Summary of Comments on PDR Redlines.pdf

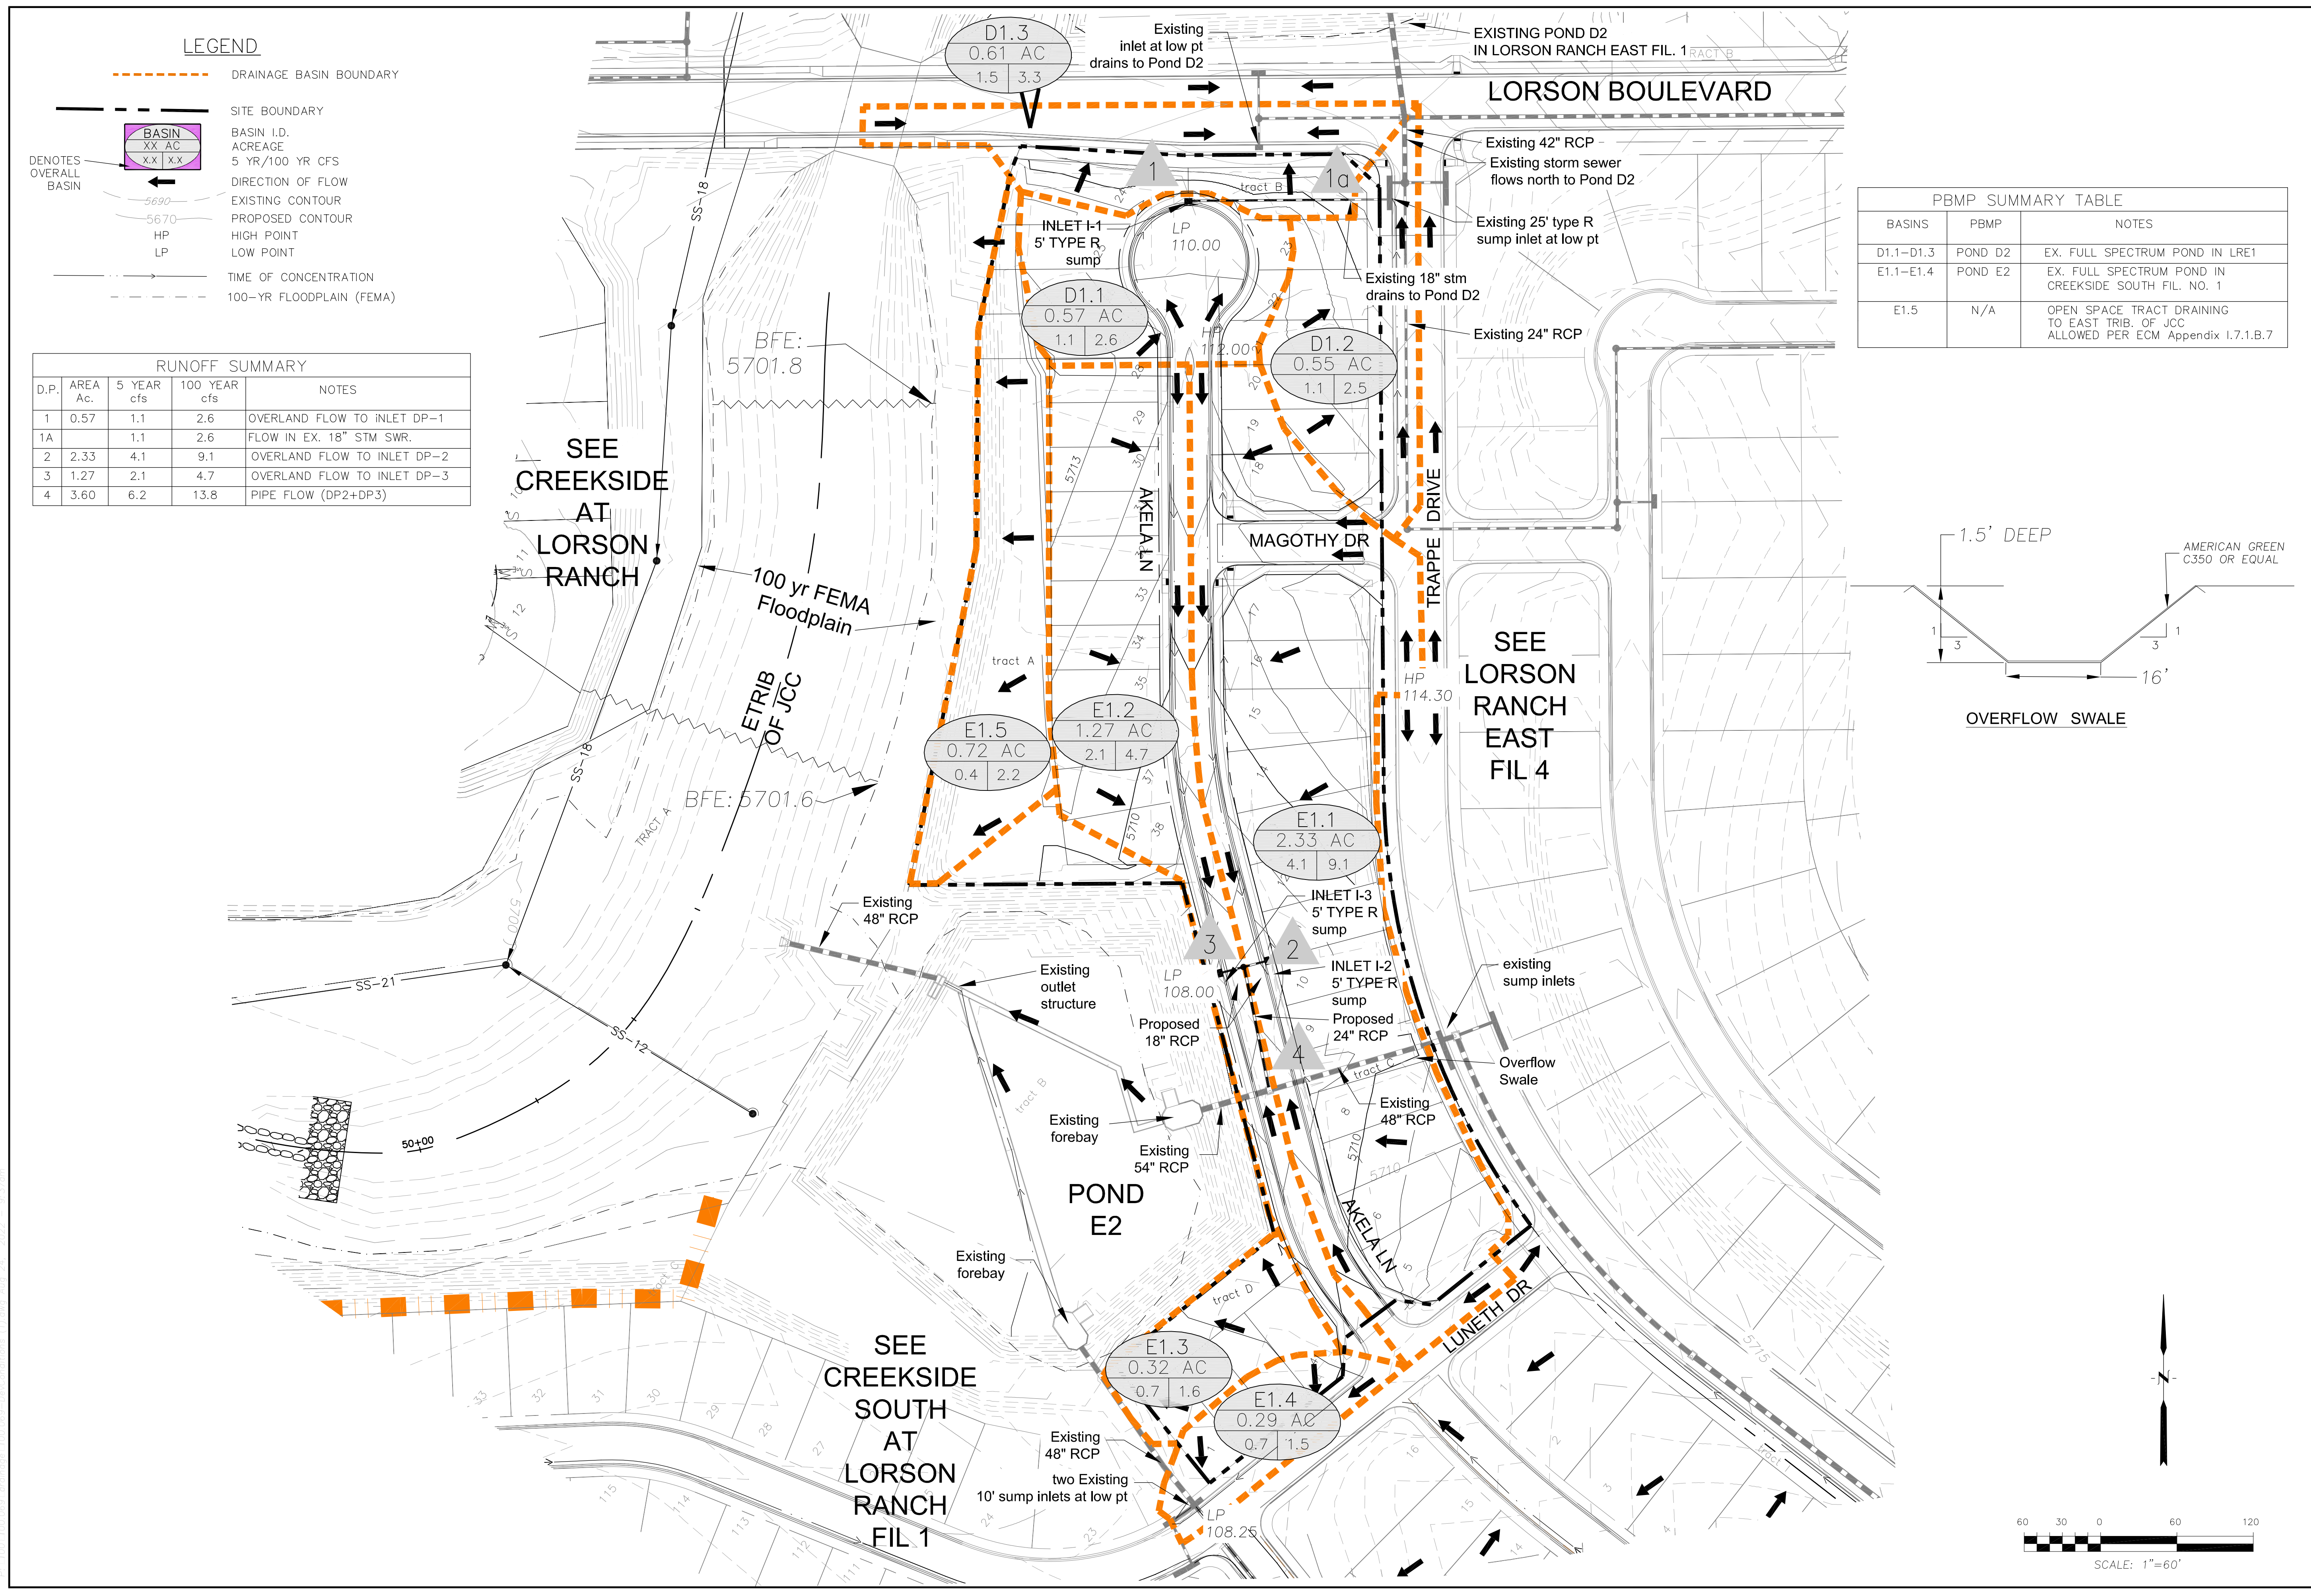
Author: CDurham Subject: Callout Date: 8/18/2022 3:29:02 PM
Include "line" across channel for BFE location

Author: CDurham Subject: Callout Date: 8/18/2022 3:27:12 PM
This area needs to be included as a basin

Author: RSchindler Subject: Sticky Note Date: 8/24/2022 9:07:21 AM
added

Author: RSchindler Subject: Sticky Note Date: 8/24/2022 9:07:34 AM
added to ex-e1
